Oulton Parish Council (OPC) have recently sent in comments in regard to the **‘Response to Secretary of State Letter dated 9 July 2021 - Updated information on cumulative and in combination effects with the Dudgeon and Sheringham Shoal Extension Projects’** this was sent on 10th September 2021 and accepted on the 23rd September.

OPC would therefore like the opportunity to highlight some further issues from the **cumulative impact** document.....

Royal HaskoningDHV
Enhancing Society Together

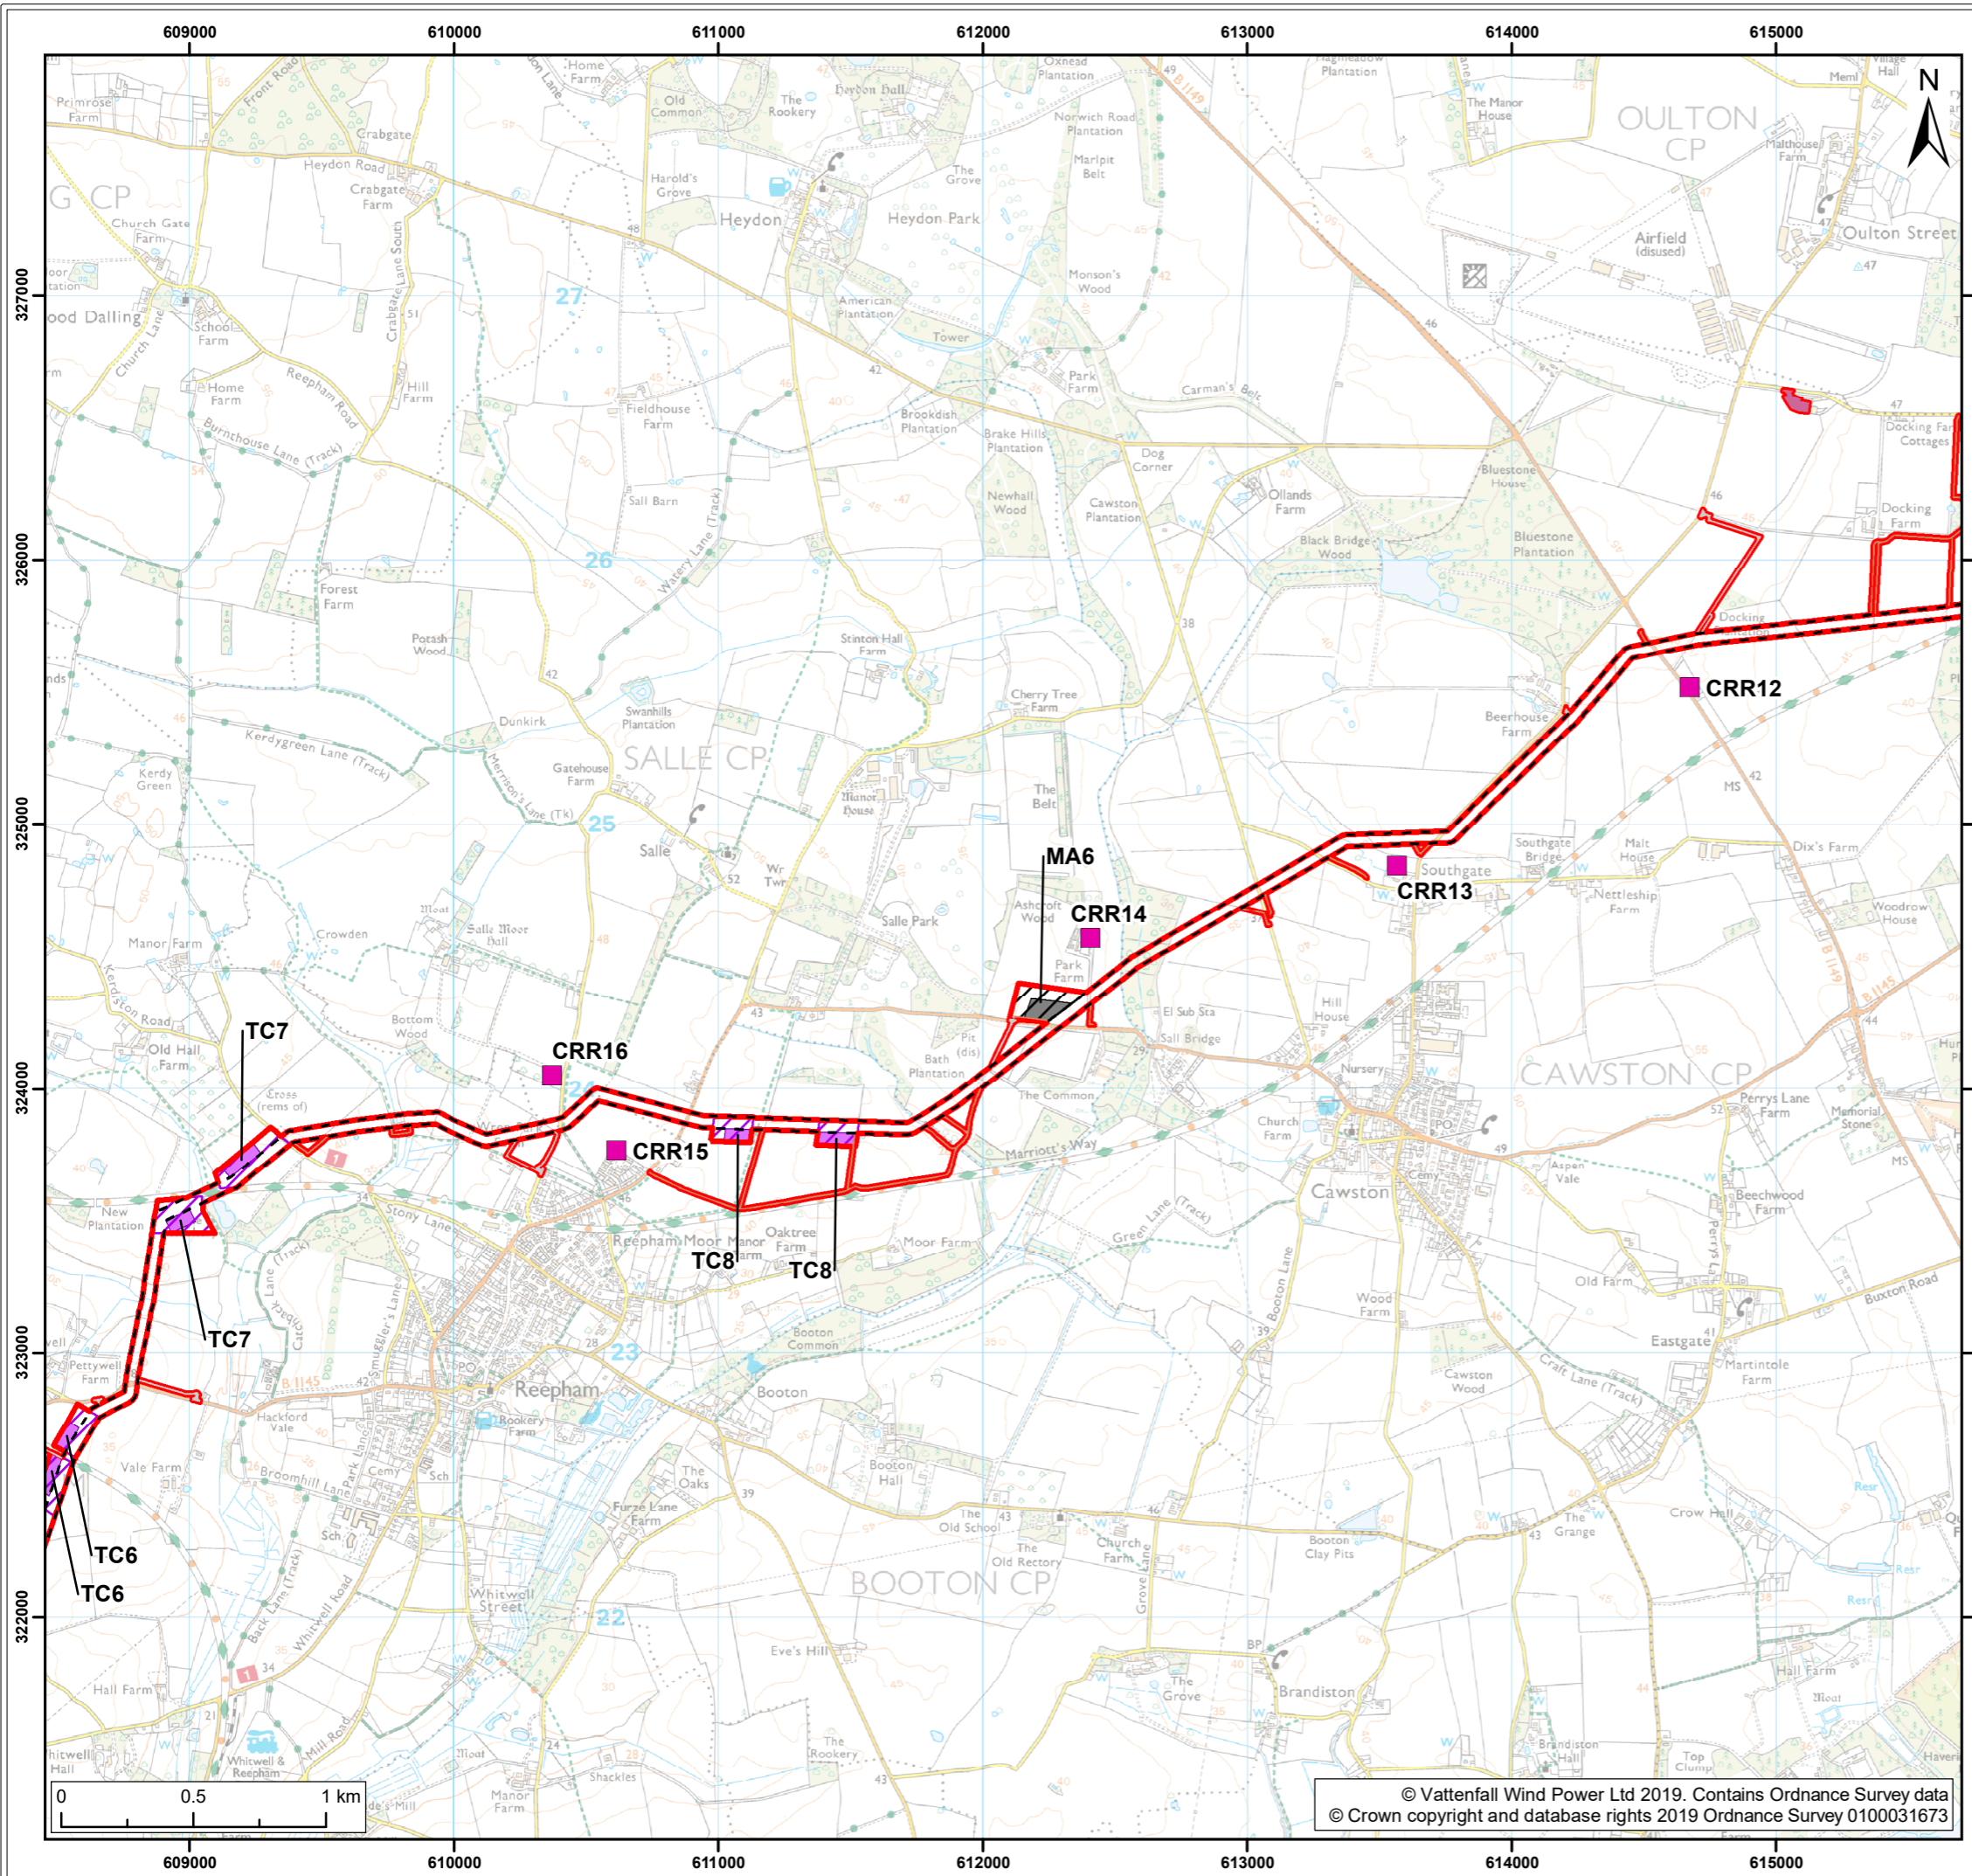
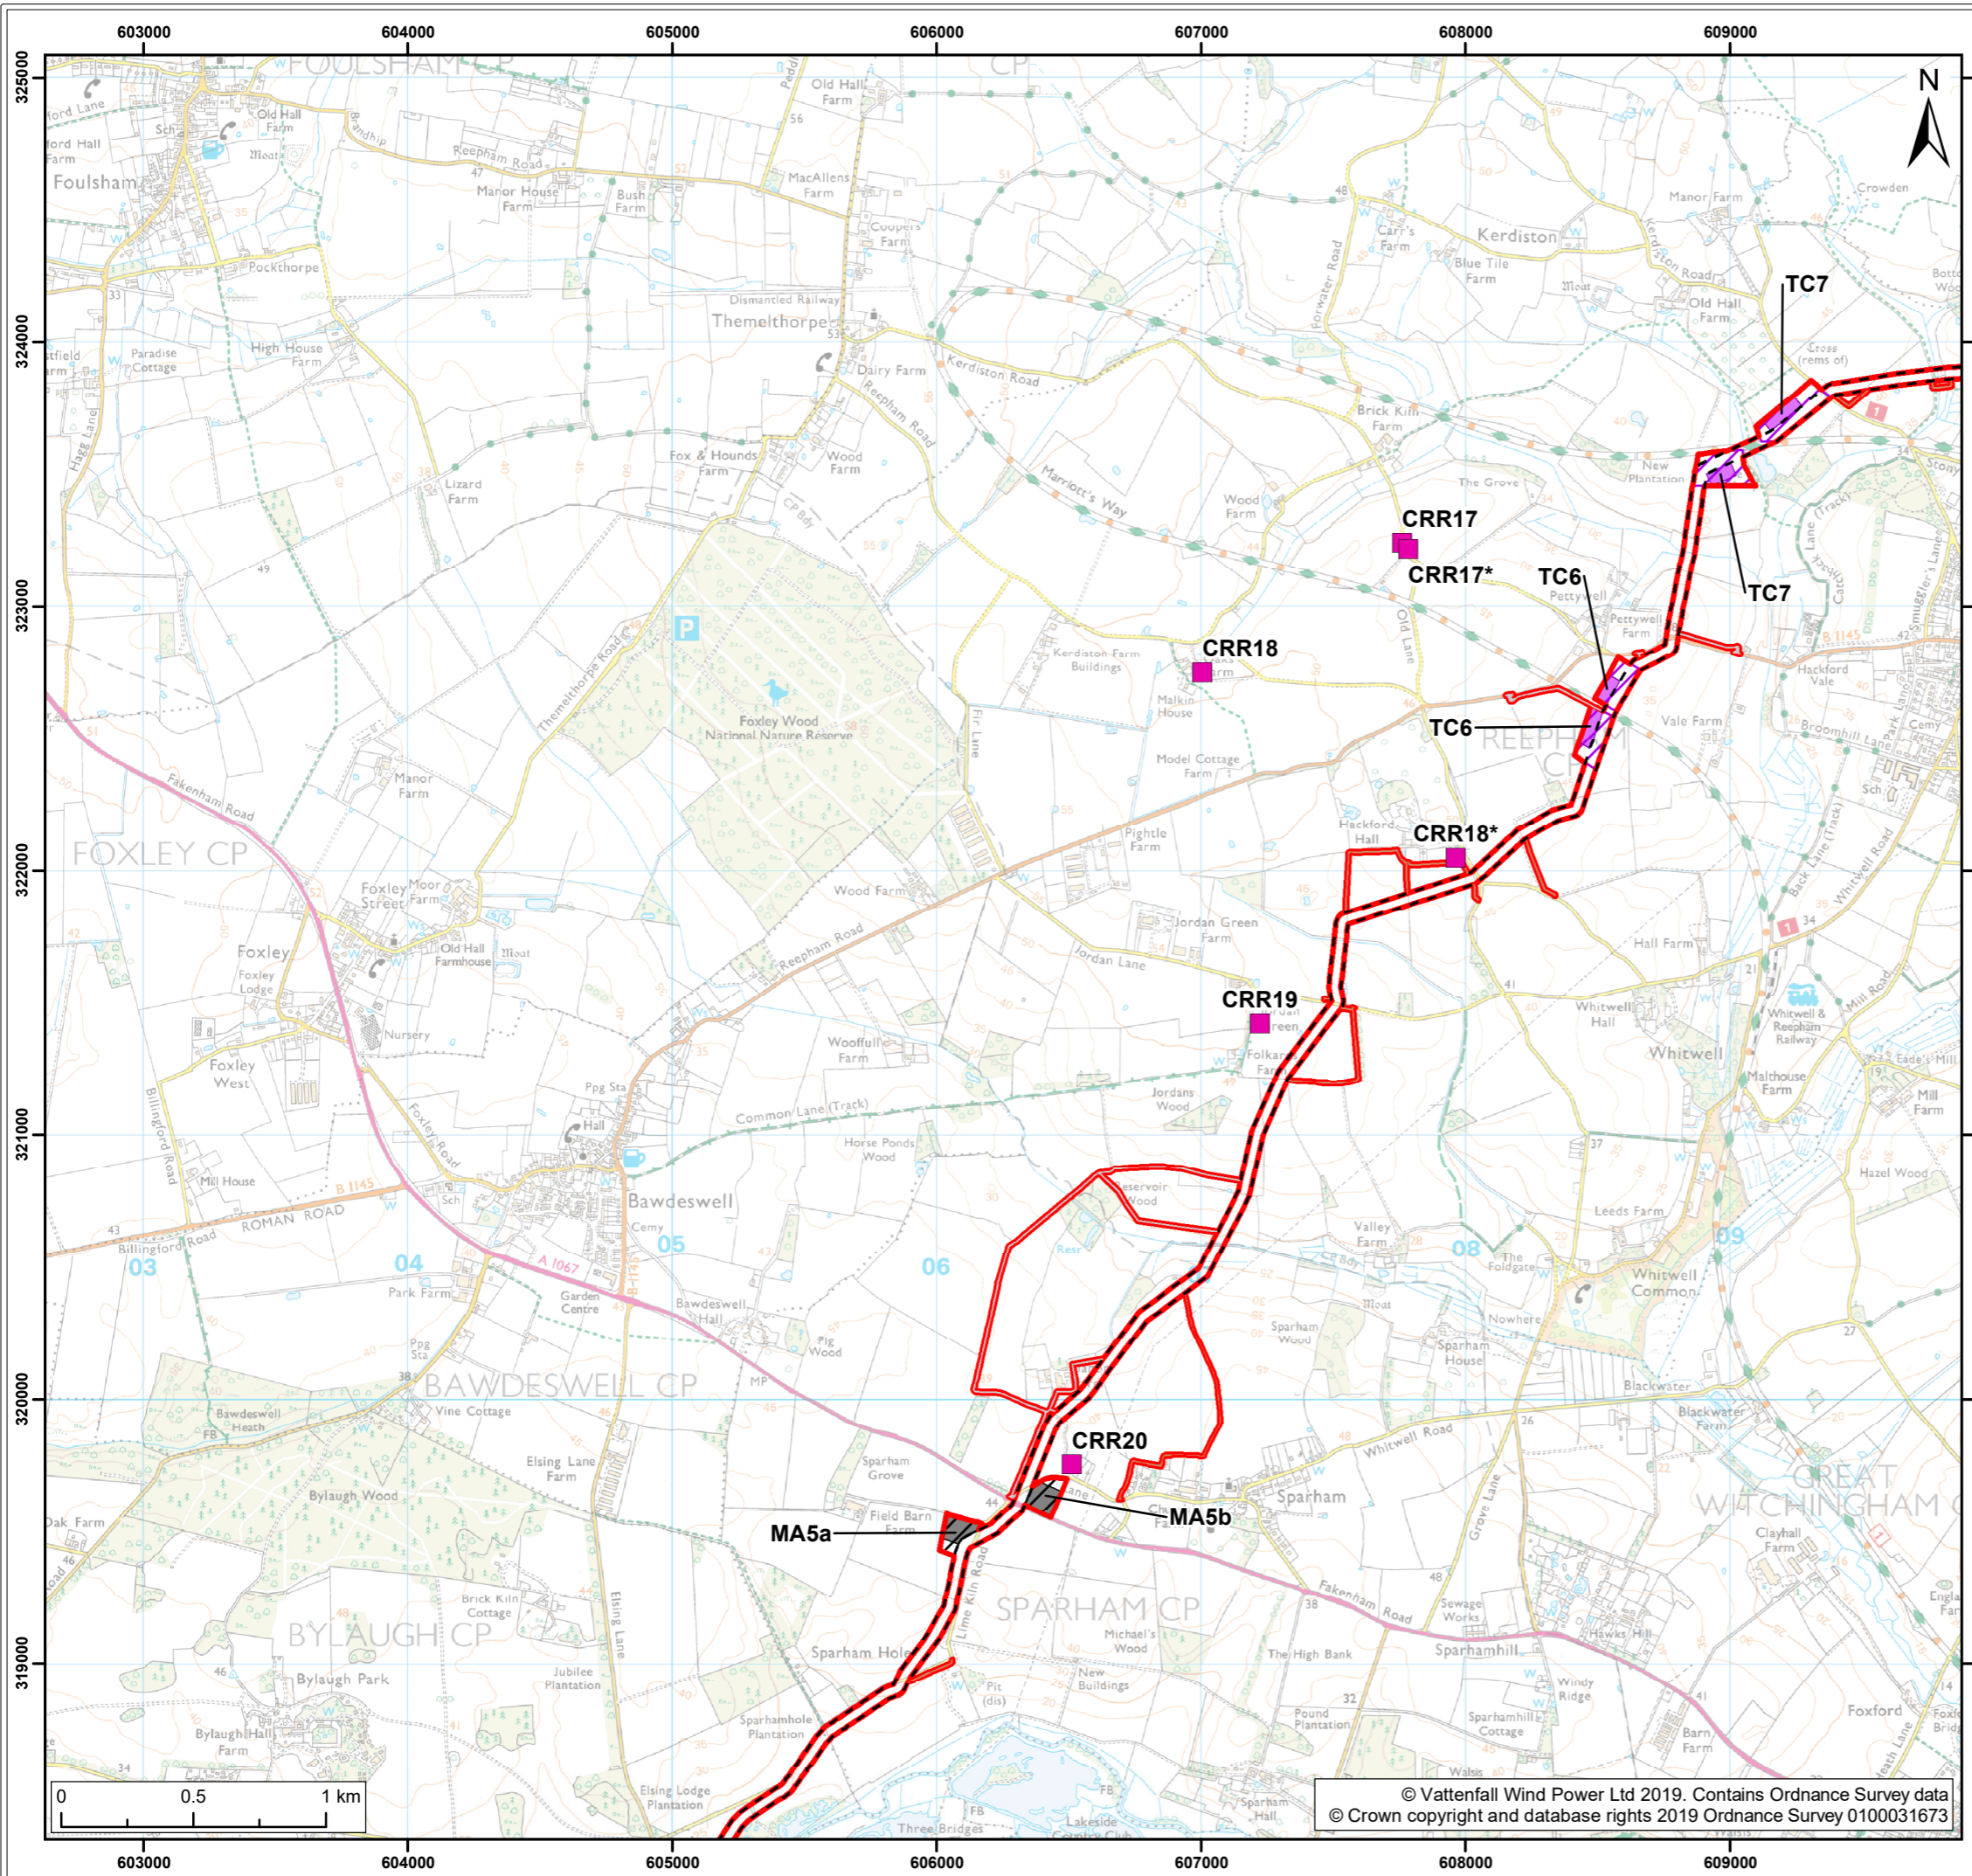
The proposed DEP and SEP onshore cable route would cross the Norfolk Boreas cable route east of Cawston. There is a common noise sensitive receptor in proximity to both projects (CRR12 as shown on Figure 25.2 of ES chapter 25 Noise and Vibration [APP-470]). Construction noise at CRR12 for Norfolk Boreas was assessed as no impact during the peak construction phase (2023/2024). The DEP and SEP cumulative impact assessment concluded that there would be no cumulative construction noise impacts with Norfolk Boreas.

It should be noted that there will be additional noise at this **sensitive receptor (CRR12)** as there will be the need for a HDD crossing of the B1149 at this point, for Norfolk Boreas Scenario 2. This has been excluded from the cumulative impact. This would also apply to DEP/SEP.
